## TRANSPORT ASSESSMENT ADDENDUM

Project:	Land off Ploughley Road, Ambrosden, Oxfordshire – 22/02866/OUT	Page 1 of 6
Subject:	Site Access Arrangements	Date: 02/12/2022

Technical Note Prepared by:	Approved for Issue by:
Christopher Miles <b>Transport Consultant</b>	Max Thurgood <b>Director</b>

JUNCTION VISIBILITY
SCALE 1:250

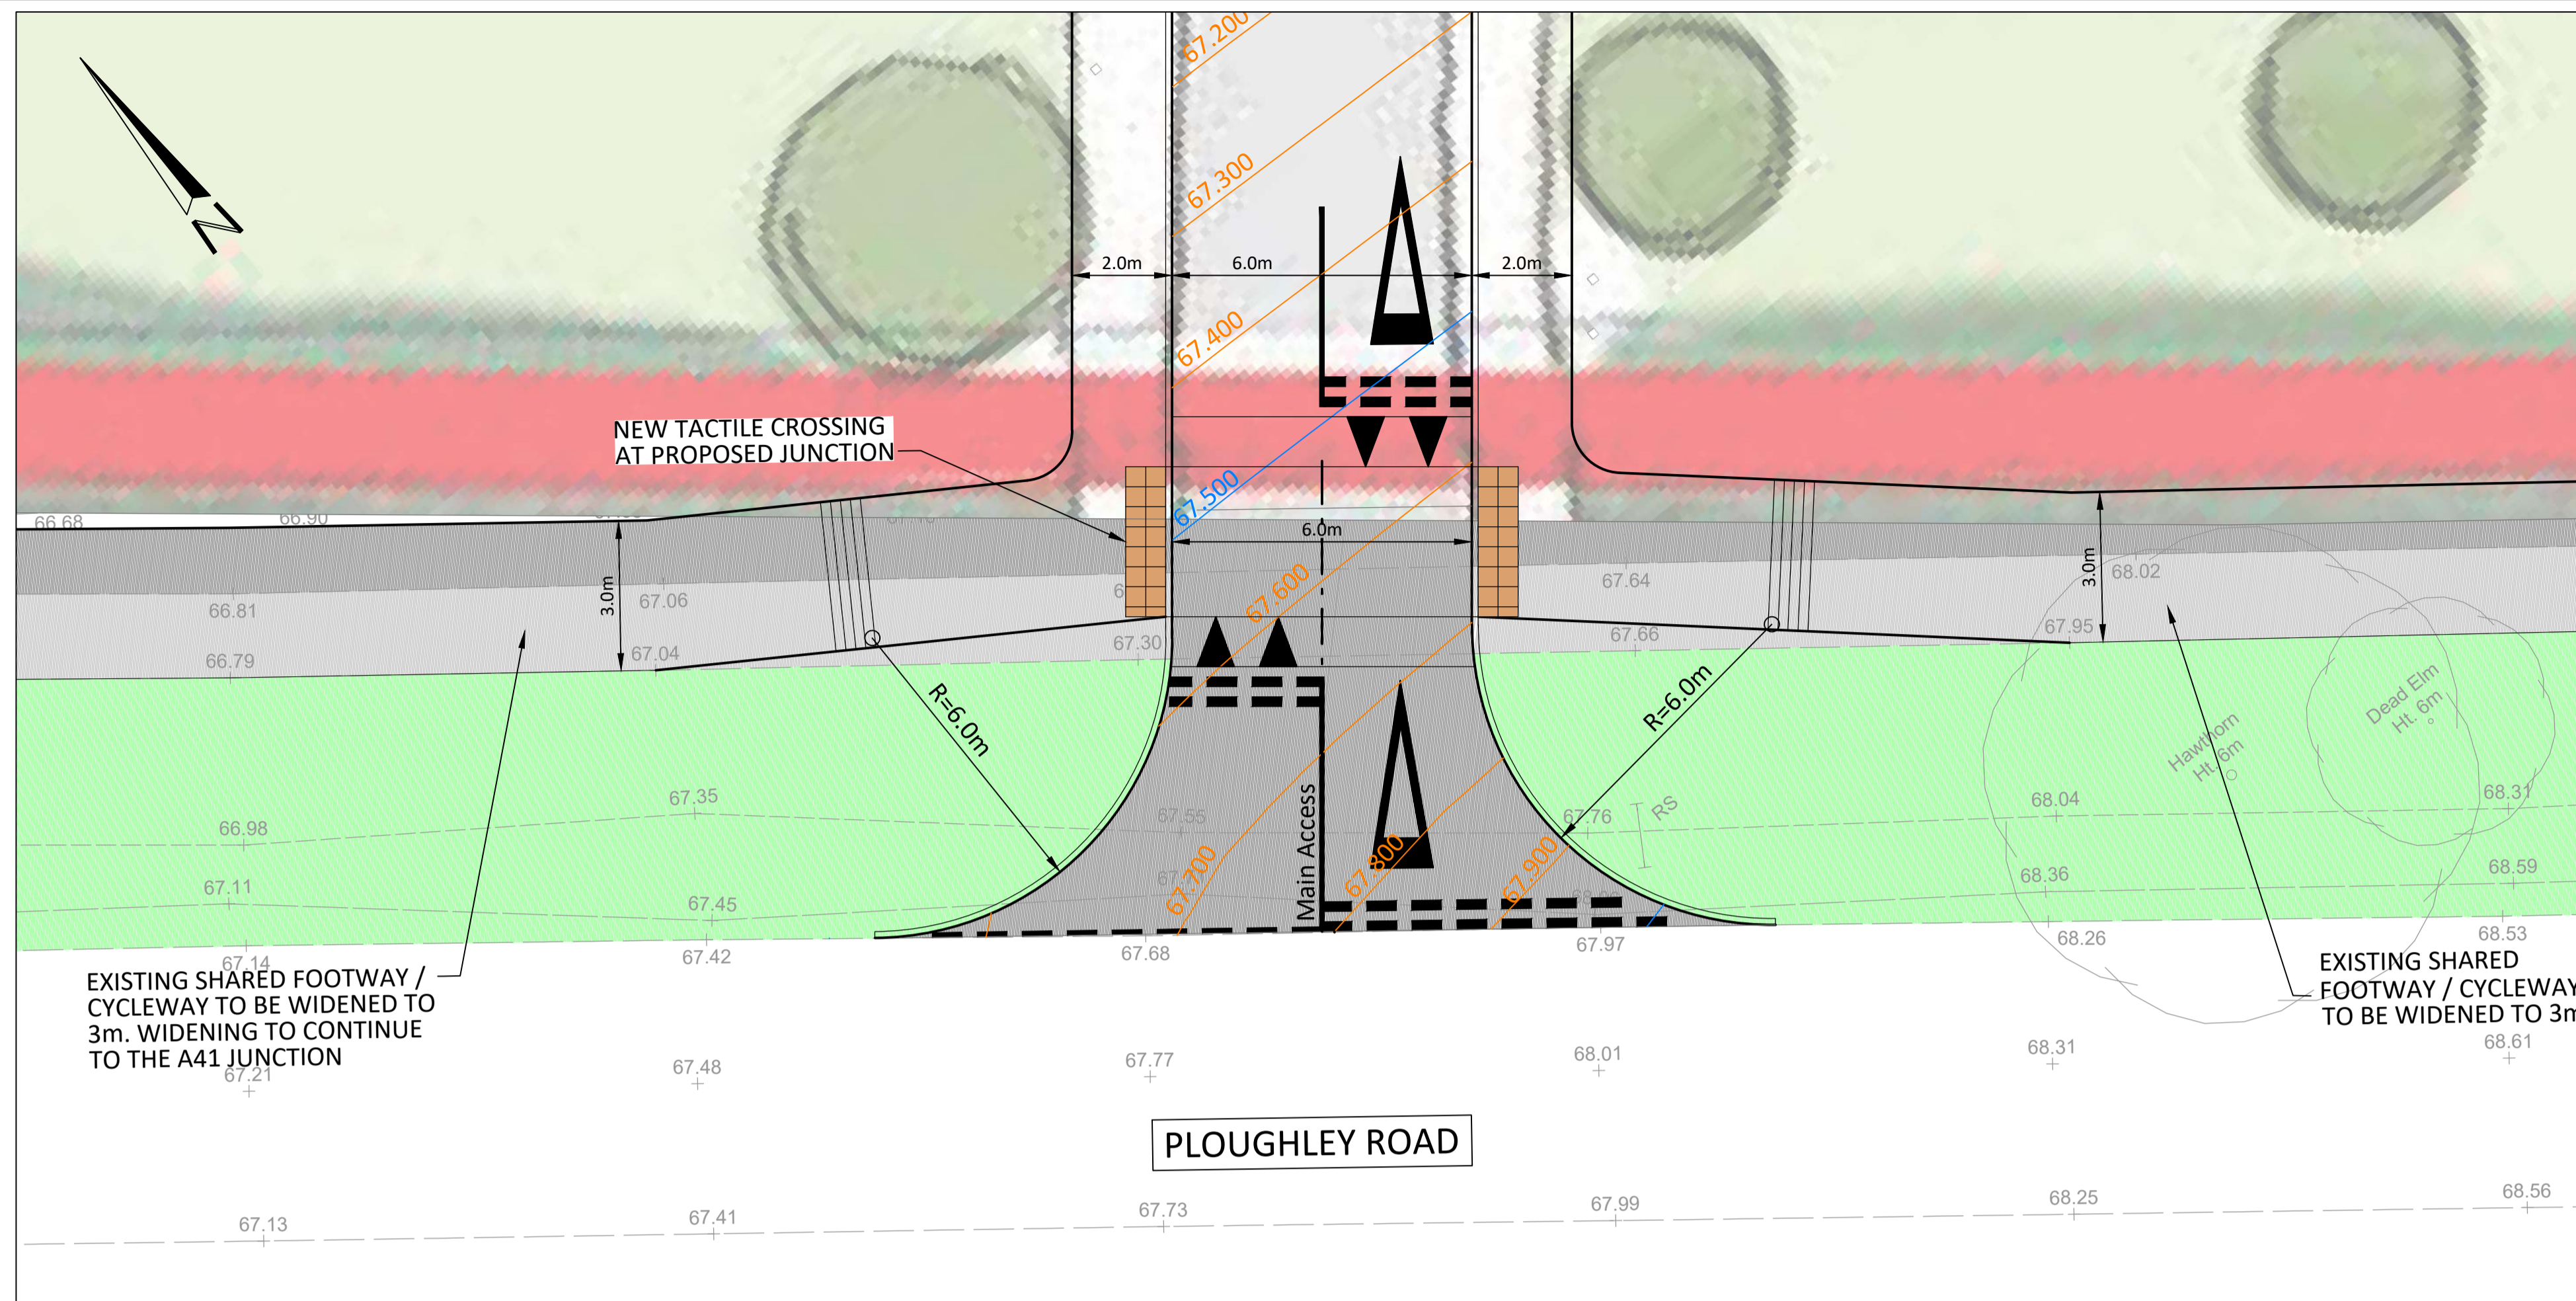
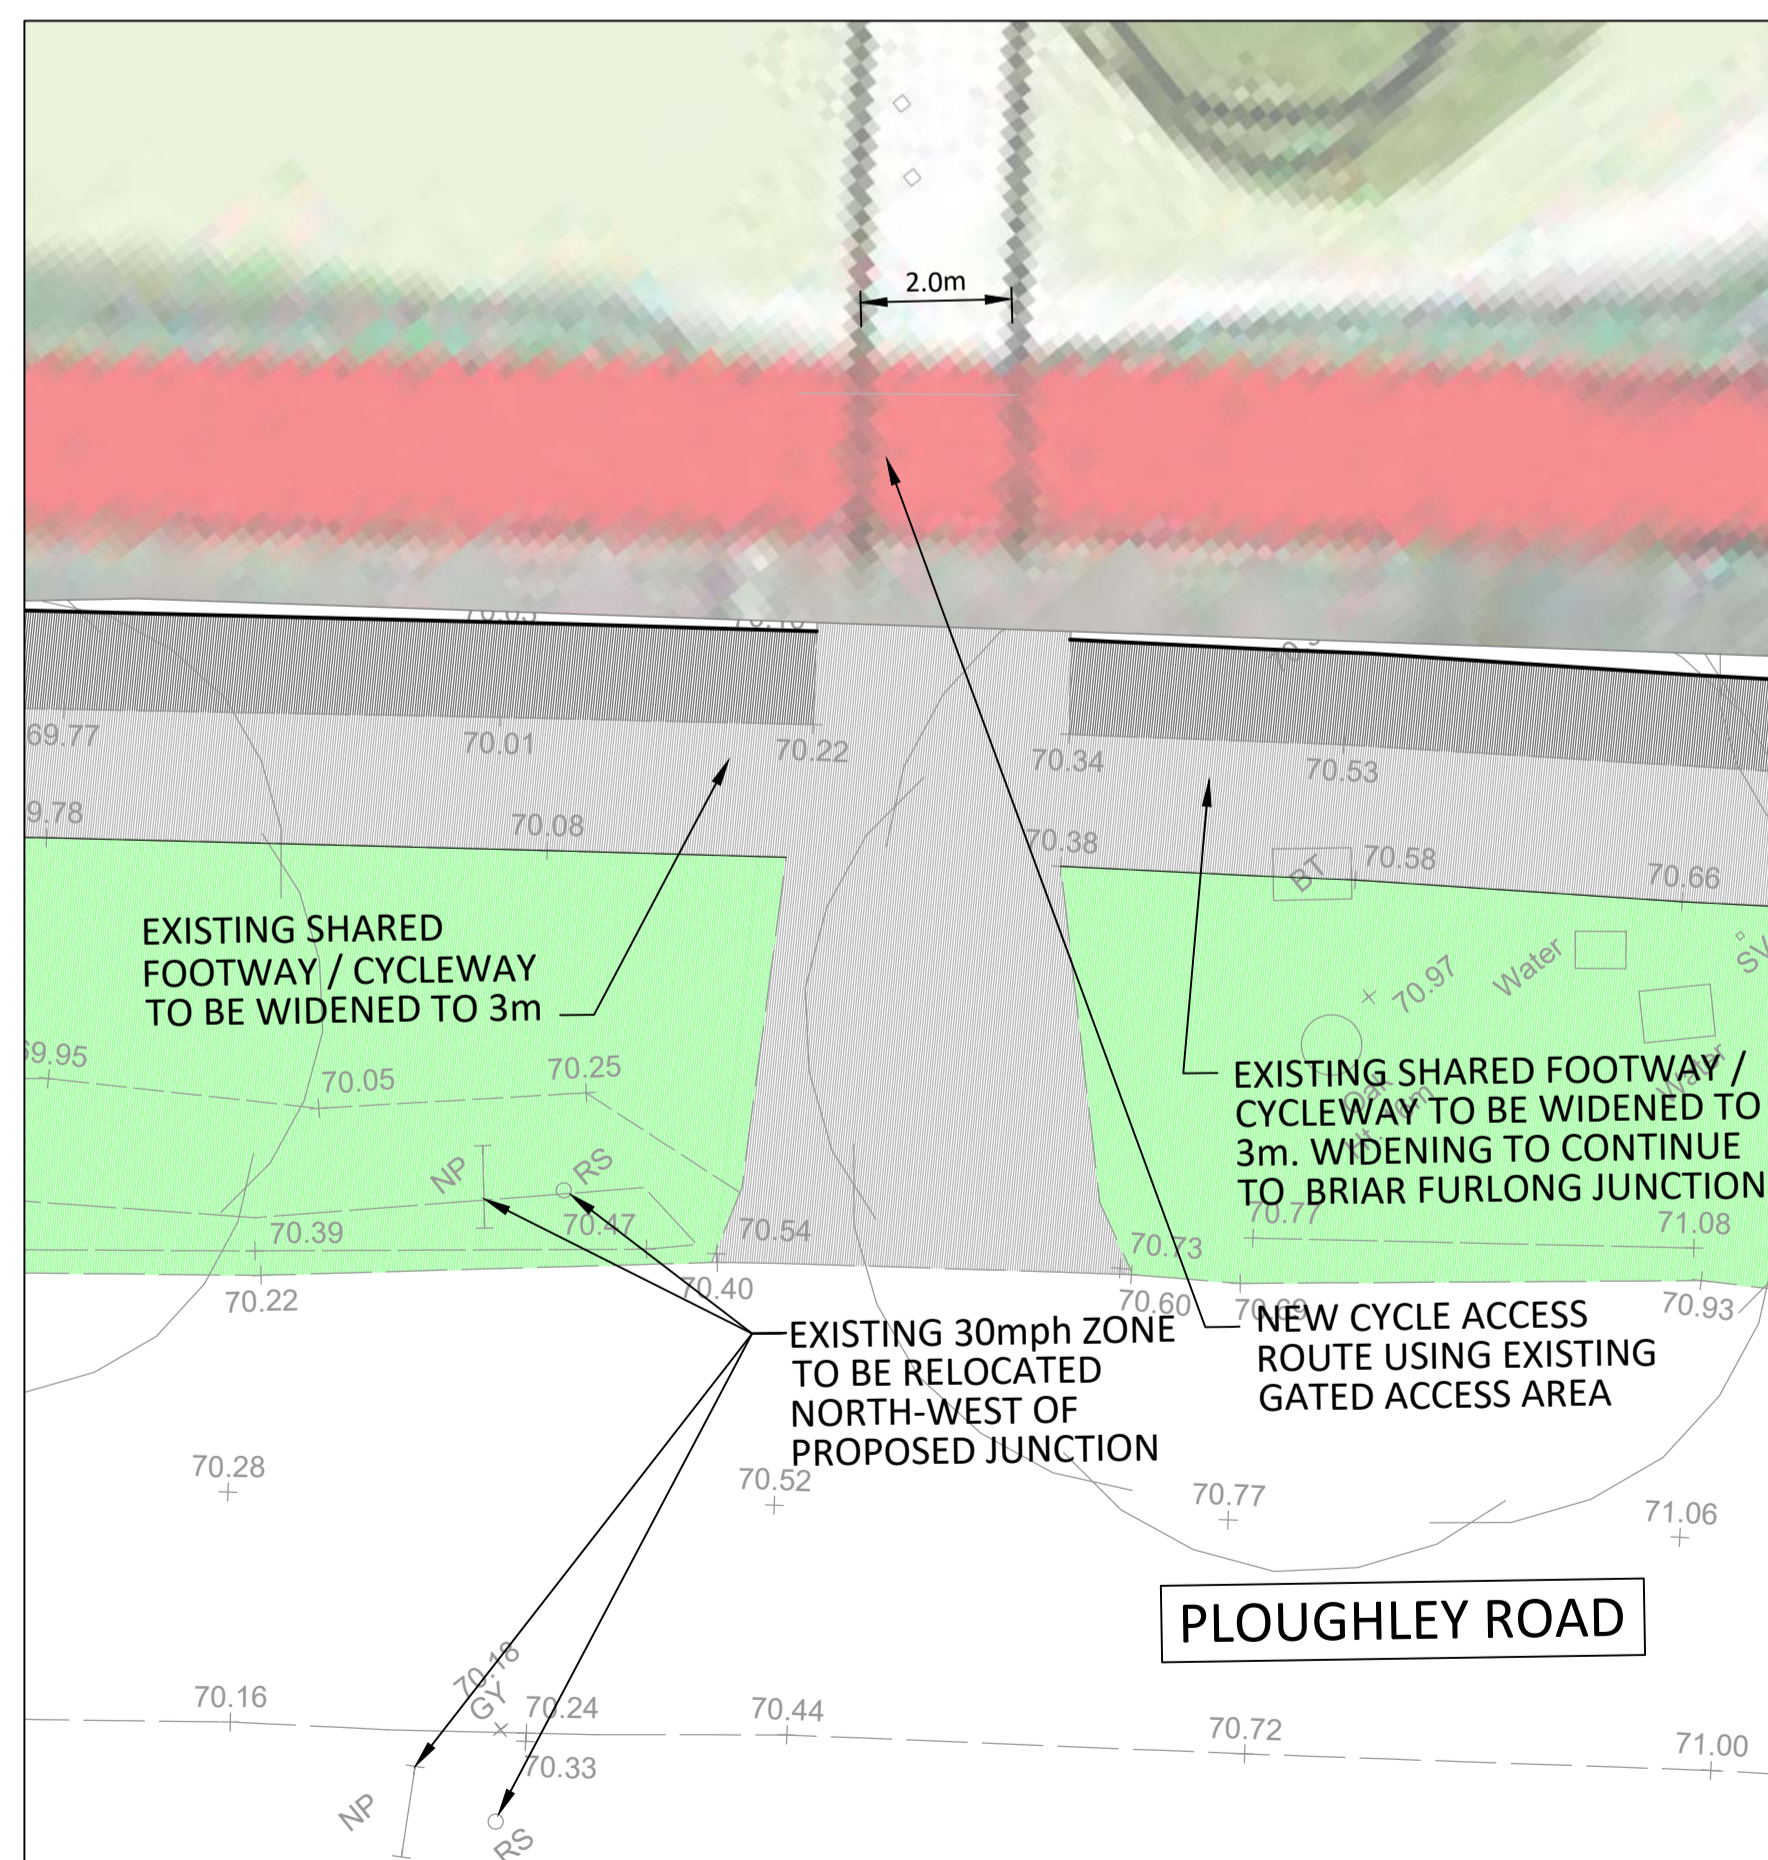
Given the above, OCC consider that the available visibility from the site access is insufficient for the anticipated vehicle speeds along Ploughley Road, despite the proposed change to the speed limit, and this is a reason to **object**.

The bellmouth access must include a cycletrack crossing in accordance with LTN 1/20, as noted in sect. 5.3 of the TA.

Use of the formula provided within Section 10 of MfS2 identifies that a 70m splay equates to an 85<sup>th</sup> percentile traffic speed of approximately 37mph. Given the proposed traffic calming layout, the reduction in speed limit and the appropriate design guidance, it is considered that 85<sup>th</sup> percentile speeds of approximately 37mph are unlikely to be exceeded and that the 70m visibility splays shown on the revised site access plans are therefore both appropriate and acceptable.

The OCC consultation response also identifies that the bellmouth access junction must include a cycletrack crossing in accordance with Local Transport Note 1/20: Cycle Infrastructure Design. The layout of the access junction has therefore been amended to give greater priority to the existing shared use path where it crosses the proposed site access (plan 0007\_P05 in Appendix B).

The path is shown as being widened to 3m where it crosses the access road and slightly realigned into the site to increase the offset distance from the Ploughley Road kerb line to approximately 6m. This in turn allows the introduction of a raised table to give pedestrians and cyclists using the shared use path priority over vehicles entering and departing the residential development. This can also be reinforced through the provision of formal ‘give way’ road markings on the site access.

This arrangement complies fully with the LTN1/20 design guidance including the provision of appropriate car driver to cycle path visibility splays in both directions.
